Planning Application Ref: Y/63/19/RES

Location: Bonhams Field, Main Road, Yapton, BN18 0DX

Description of works: **Approval of reserved matters following the grant of Y/1/17/OUT for 56no. dwellings with associated open space & creation of new access. This application affects the character & appearance of the Yapton (Main Road) Conservation Area & affects the setting of listed buildings**

scheme: Bonhams Field
Yapton
client: Seaward Properties Limited
drawing: Tree Reference Plan
date: August 2016
scale: 1:500@A1
dwg no: SEA20727-03A
drawn: RA checked: MW

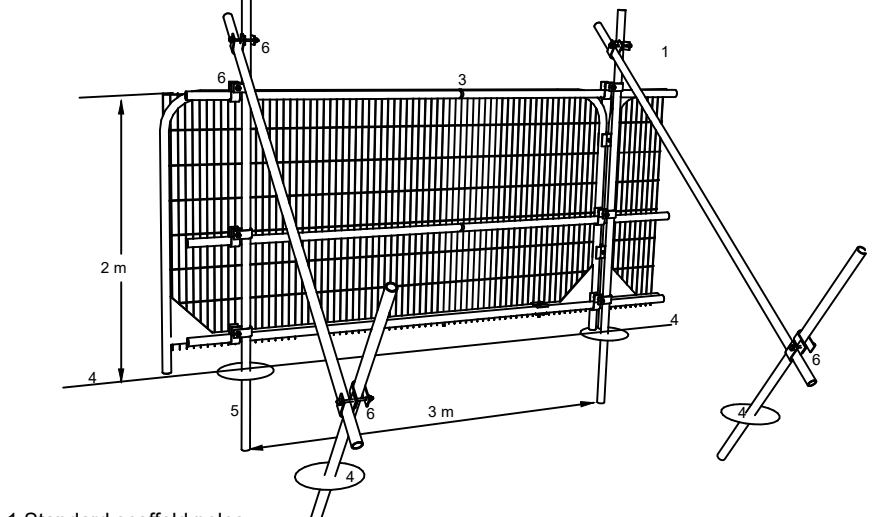
- Introduction of garden boundary fences within root protection areas (RPAs) of off-site trees which overlap the development. Unresolved but adequate mitigation measures described in AMS. Supervision by project arboriculturist for this element of the project will be required and secured by written agreement following pre-commencement site meeting (see recommended condition 1).

- Introduction of plots alongside property known as 'Denzil' at the expense of open space (a gateway feature with potential for high visual impact tree(s)) and within RPA of off-site trees which overlap the development. Unresolved.

- Introduction of hard-surface parking bays within RPA and canopy spread of category A oak (T30), tree worthy of statutory protection. Resolved.
 - Loss of north-south open space along east boundary of site which captured a substantial linear group of trees that contribute to the landscape. Unresolved.

- ✧ The current Arboricultural Impact Assessment & Method Statement and Tree Protection Plan clearly do not support this Reserved Matters layout which if ultimately approved would have to be updated to address the above areas of conflict and demonstrate how retained trees would be adequately protected. Resolved, following submission of updated Tree Reference (Protection) Plan 03-A.

-
- I can now recommend the above scheme for **APPROVAL**, subject to the following conditions being applied:
 1. Before the site is occupied or any machinery is introduced to the site or demolition work or construction work or alterations to existing ground levels takes place a **PRE-COMMENCEMENT Site Meeting** is to take place between the Planning Authority's Tree Officer and the Arboricultural Expert representing the site owner(s) – at this meeting all protective fencing and ground protection measures will be inspected to verify they are 'Fit for Purpose' as required under British Standard 5837:2012 and have been erected and positioned exactly as shown on the **Tree Reference Plan, dwg.no. SEA20727-03A**.
